MECKLENBURG COUNTY
Land Use & Environmental Services Agency

MEMORANDUM

To: Charlotte-Mecklenburg Planning Commission
From: LUESA, Mecklenburg County
Date: 7.28.22
Subject: Rezoning Petition Comments

2022-032: Canvas – Arrowood Road

**REZONING PETITION #2022-032**  
**SCHEMATIC SITE PLAN**

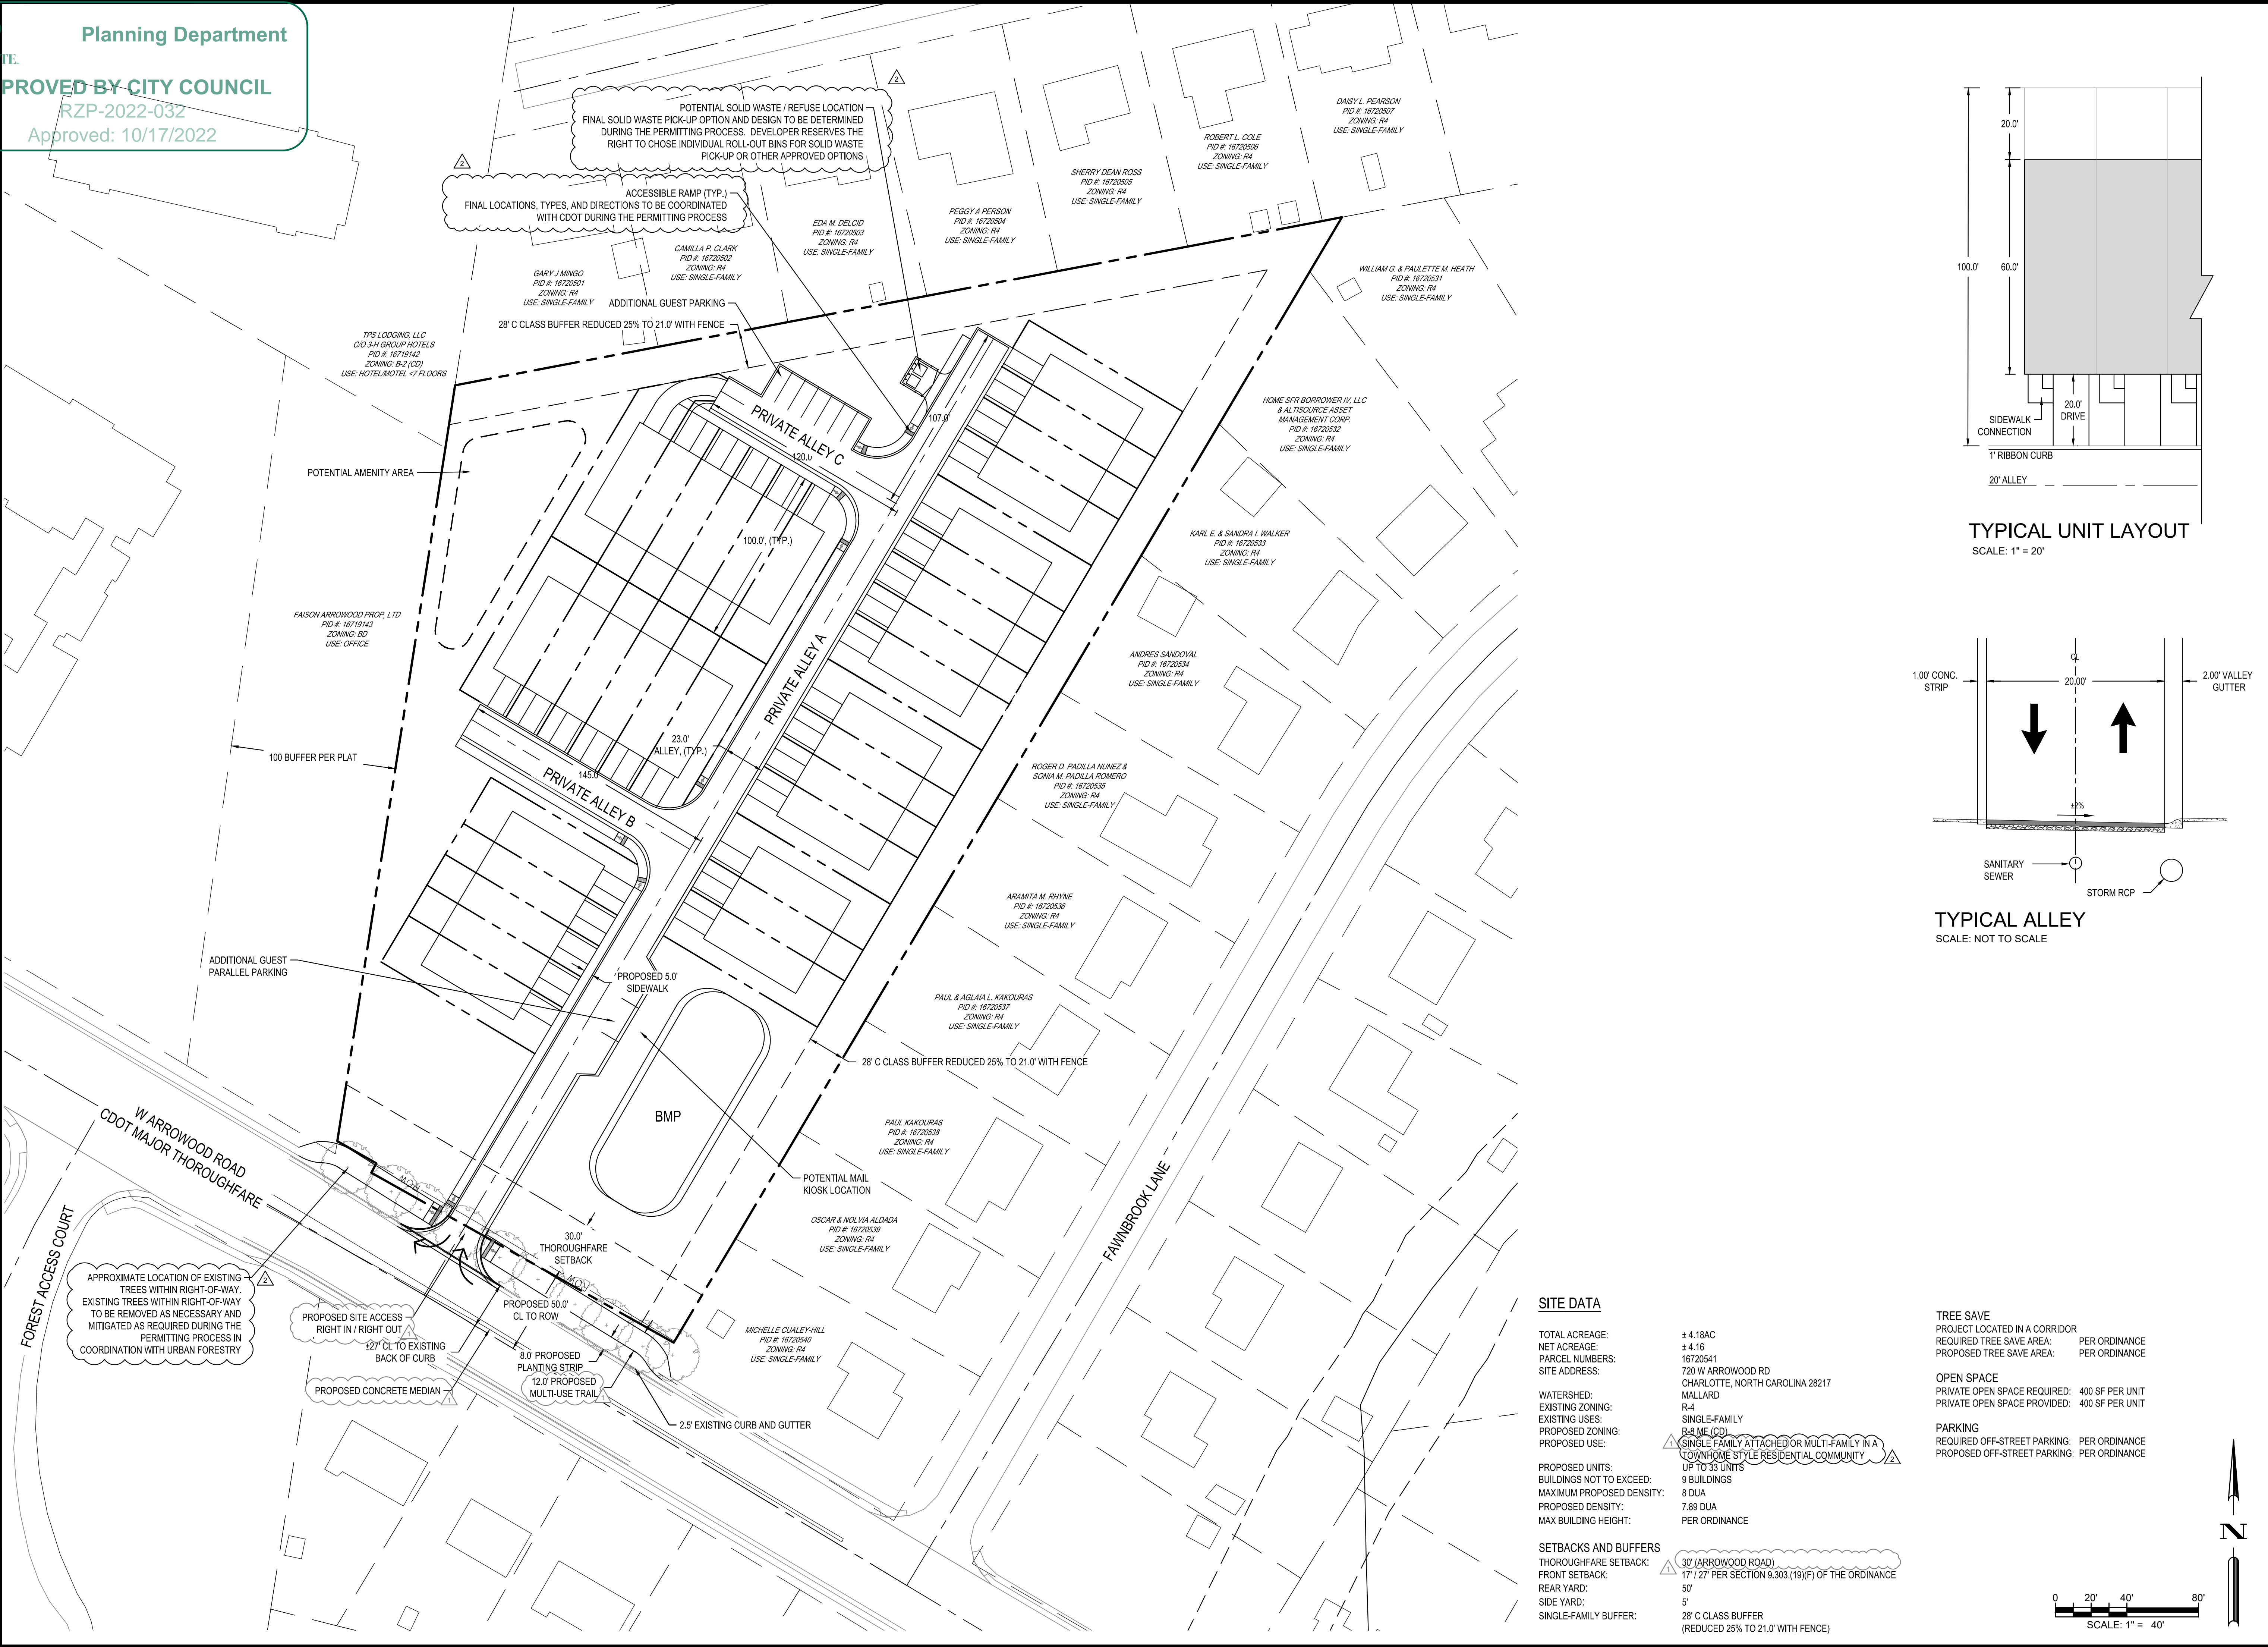
Ground Water Services Comments: Information from property records indicate that the house on parcel 167-205-41 uses or previously utilized oil, wood or coal heat. Based on this the property may contain an underground or above ground fuel oil storage tank. The tank and its contents should be removed, following applicable NCDEQ guidance, prior to any demolition or grading activity.
